Recommendation Report for Planning Permission

REF NO: FG/49/12/

LOCATION: 60 Langbury Lane
Ferring

PROPOSAL: Loft extension to rear & dormer for additional bedroom. Front roof to be gable end

Proposed West Elevation

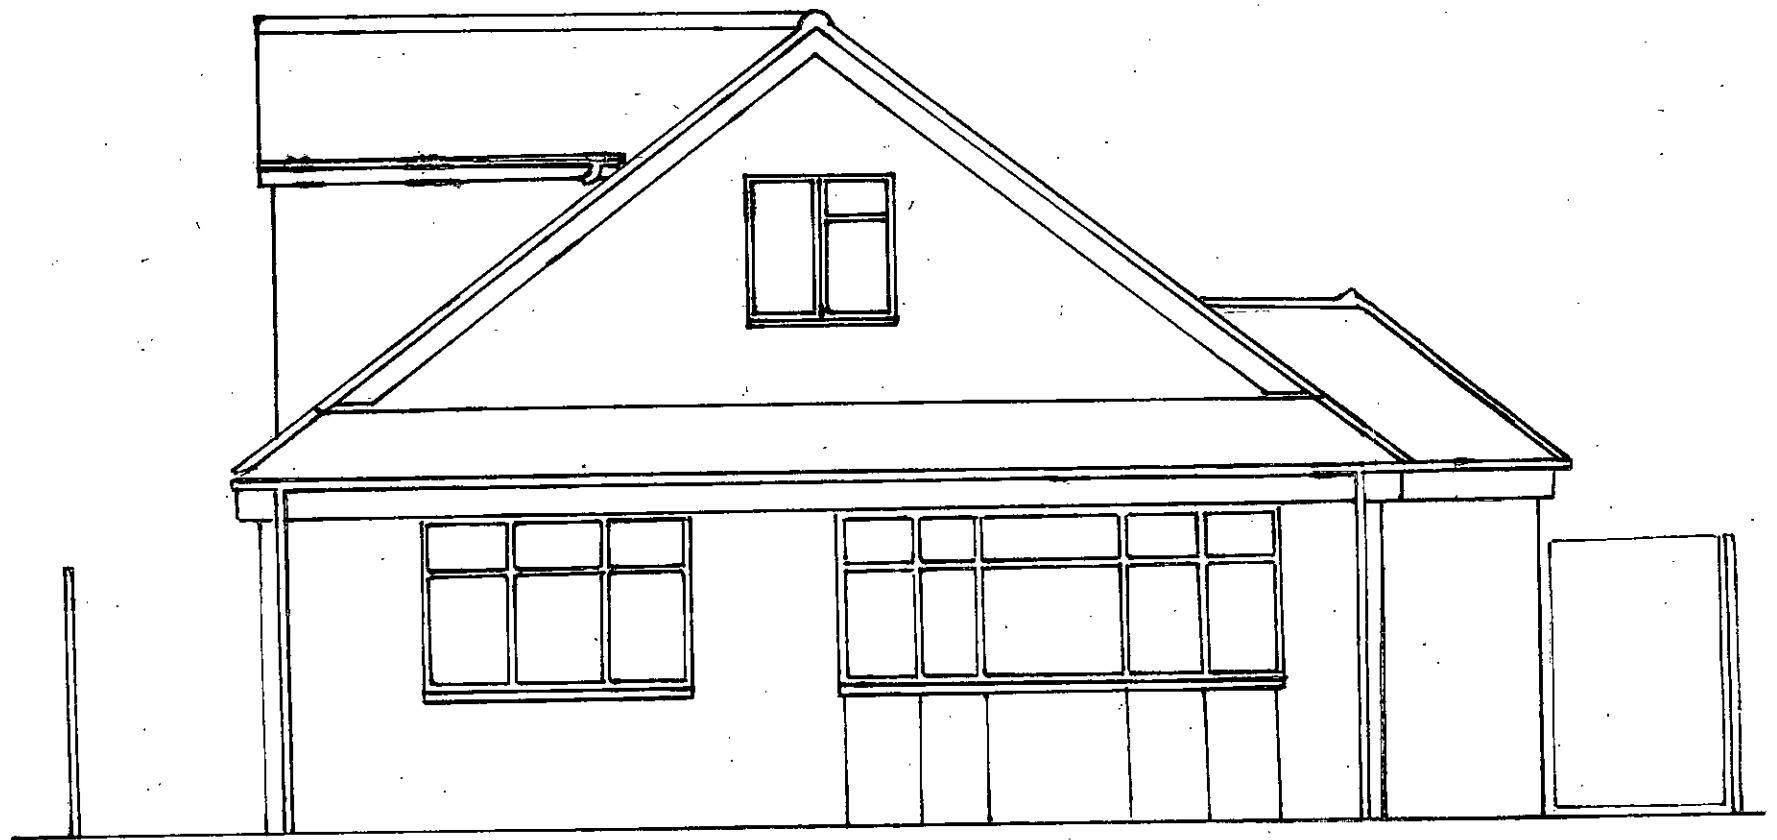
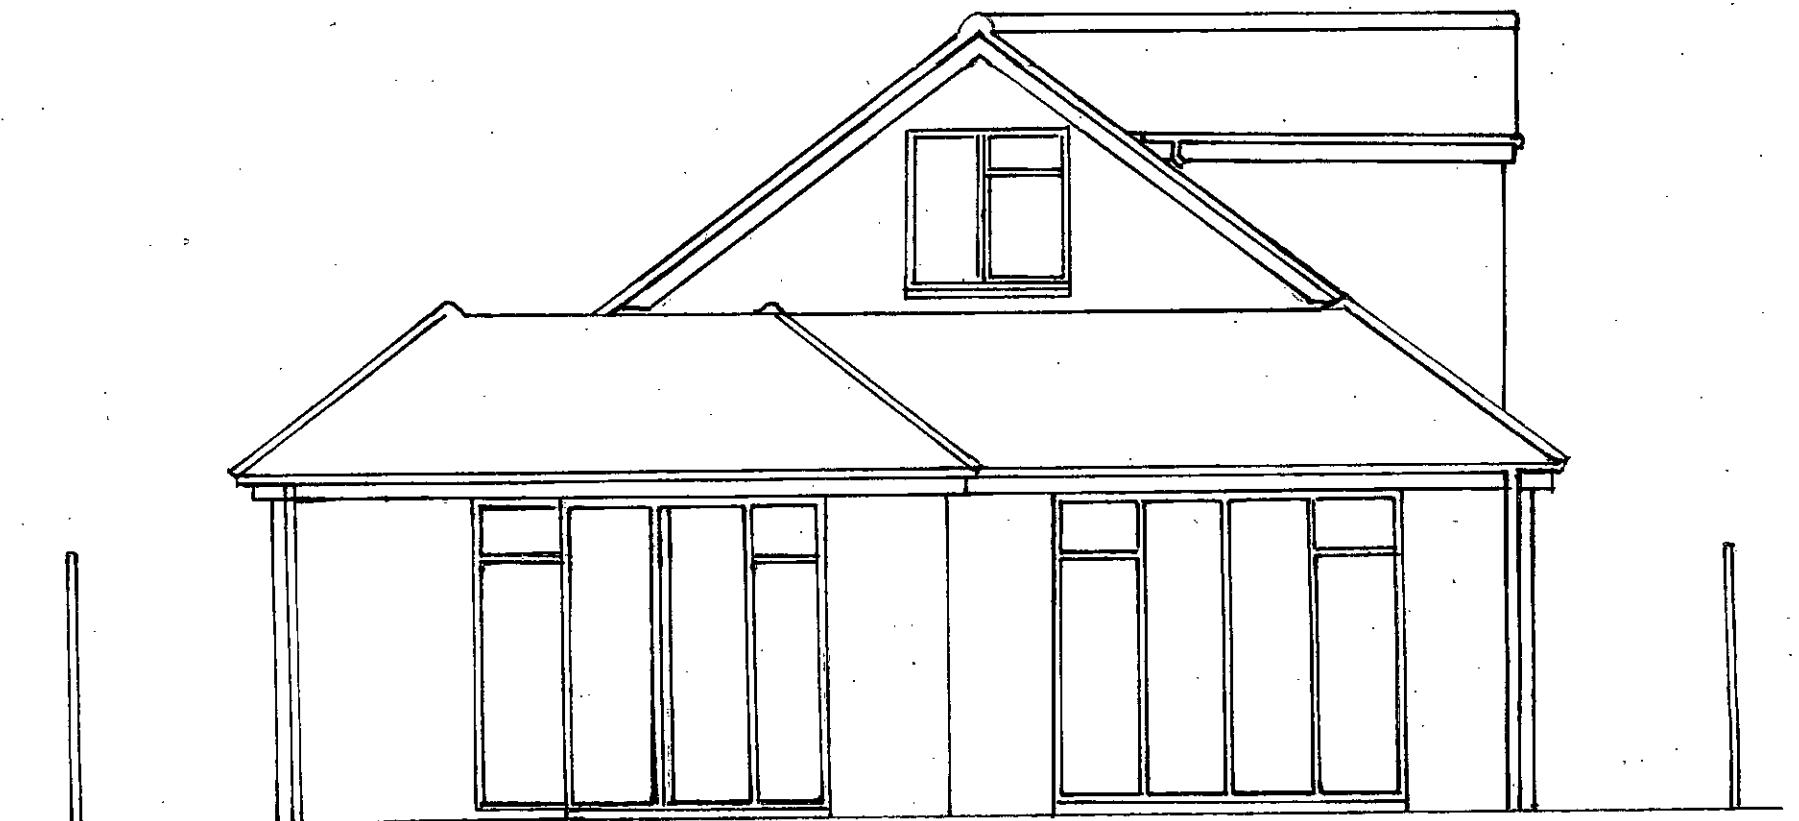
The Parish Council comments are fully noted, however in this instance they are not agreed. The street scene is varied with many types and styles of 1 and 2 storey properties noted. It is also noted that similar extensions have been carried out 54 Langbury Lane, although these have maintained half hipped roof extensions. Whilst the additions would alter the appearance of the dwelling the changes are not considered to be detrimental to its appearance.

The proposed additions would alter the existing appearance of the property with the introduction of a gable end to the front and rear elevations. However, given the varied street scene this is not considered to detract from the established appearance of the street scene and would therefore be acceptable from a visual point of view.

*Proposed South Elevation*

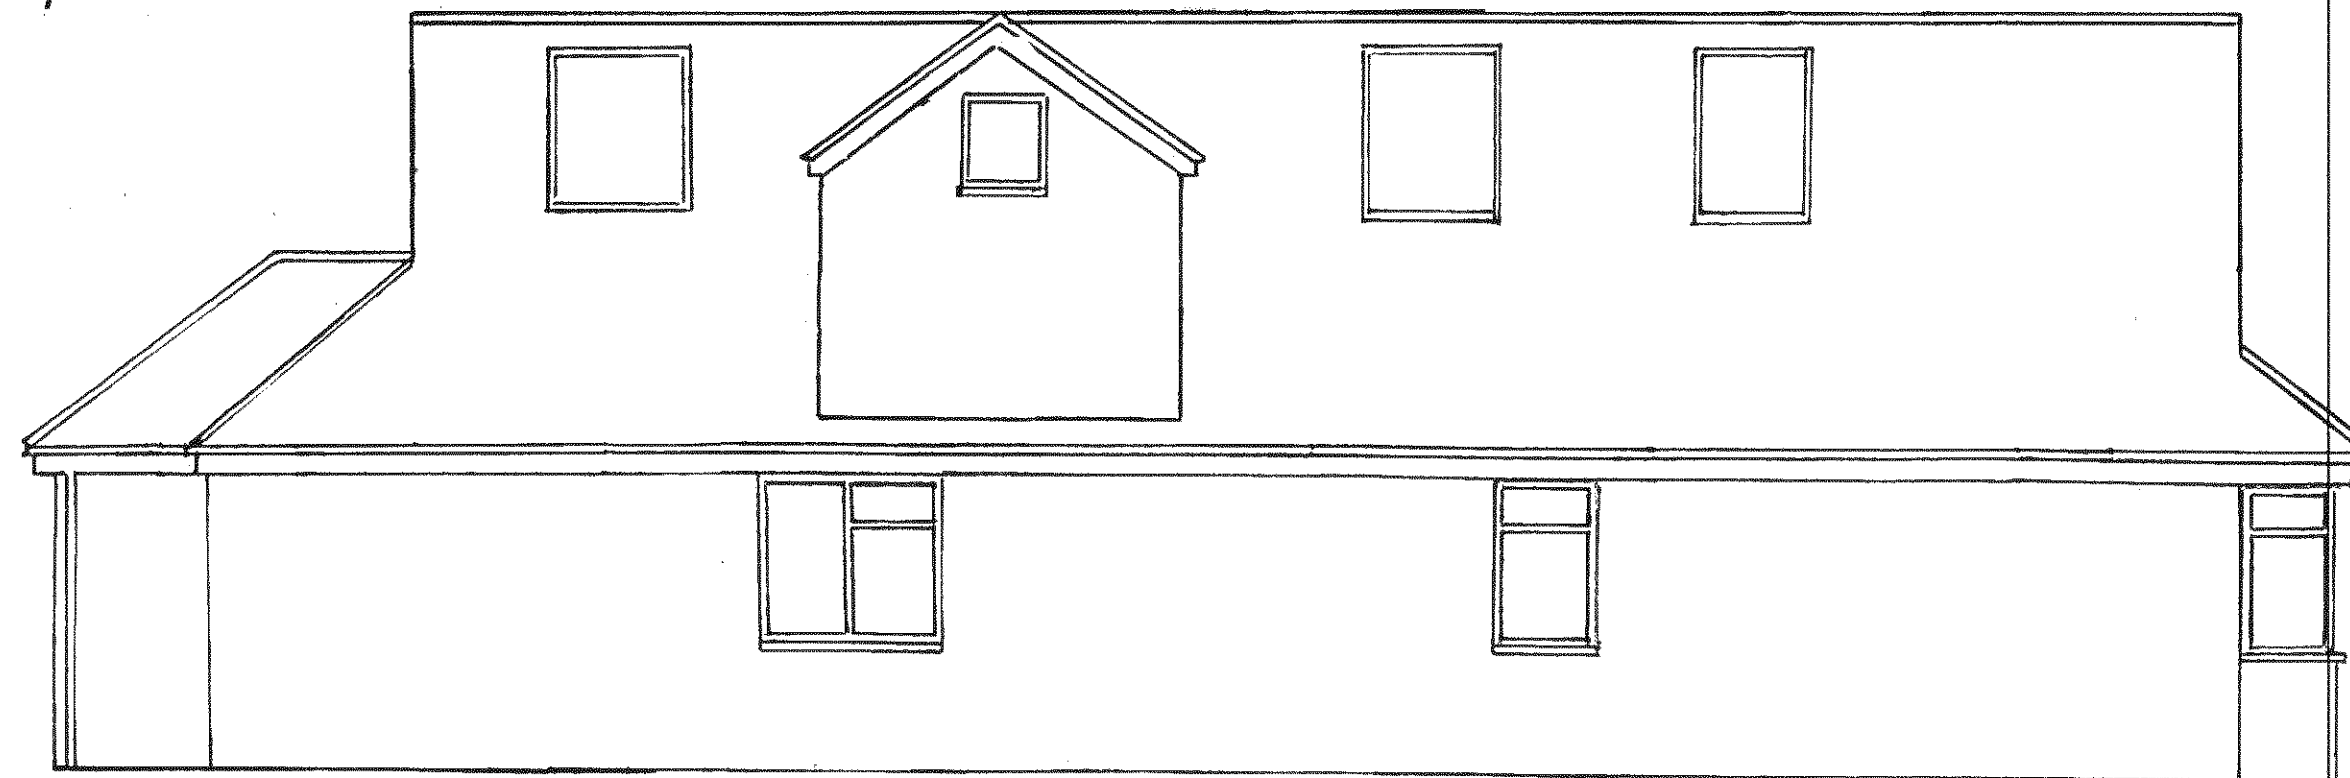
The only windows that have potential to overlook the neighbouring property to the north are the roof lights to bedroom 4 in the southern and northern roof slopes. These will be controlled by condition to ensure that they are obscure glazed and fixed to be non opening. The window within the rear gable section would overlook the rear garden of the application site with only oblique views of neighbouring sites, therefore not resulting in any undue detriment to the neighbouring property. Similarly, the scale of the additions with the eaves height of the property maintained and the roof being pitched away from the north means the resultant addition is not considered to have any unacceptable overbearing affect or loss of light to 62

The roof extensions propose further windows and roof lights to all elevations. The proposed rooflights to bedroom 4 will be conditioned to be non opening and obscure glazed and the dormer window obscure glazed; mitigating any direct overlooking of neighbouring properties. The other windows will overlook the front and rear gardens and therefore do not given rise to any direct overlooking of neighbouring sites.

The size and scale of the extensions are also acceptable with the eaves height of the property being maintained, ensuring that the roof hips away from the northern and southern boundaries at a height of 2.1 metres. This together with a minimum distance of 1.1 metre being maintained from the northern boundary will prevent any unacceptable overbearing affect or loss of light occurring as a result of the roof extensions.

- 4 The rooflights serving bedroom four on the north and south roof slopes of the dwelling shall at all times be glazed with obscured glass and fixed to be permanently non-opening.

- 5 The window within the dormer roof extension on the north roof slope of the dwelling shall at all times be glazed with obscured glass.
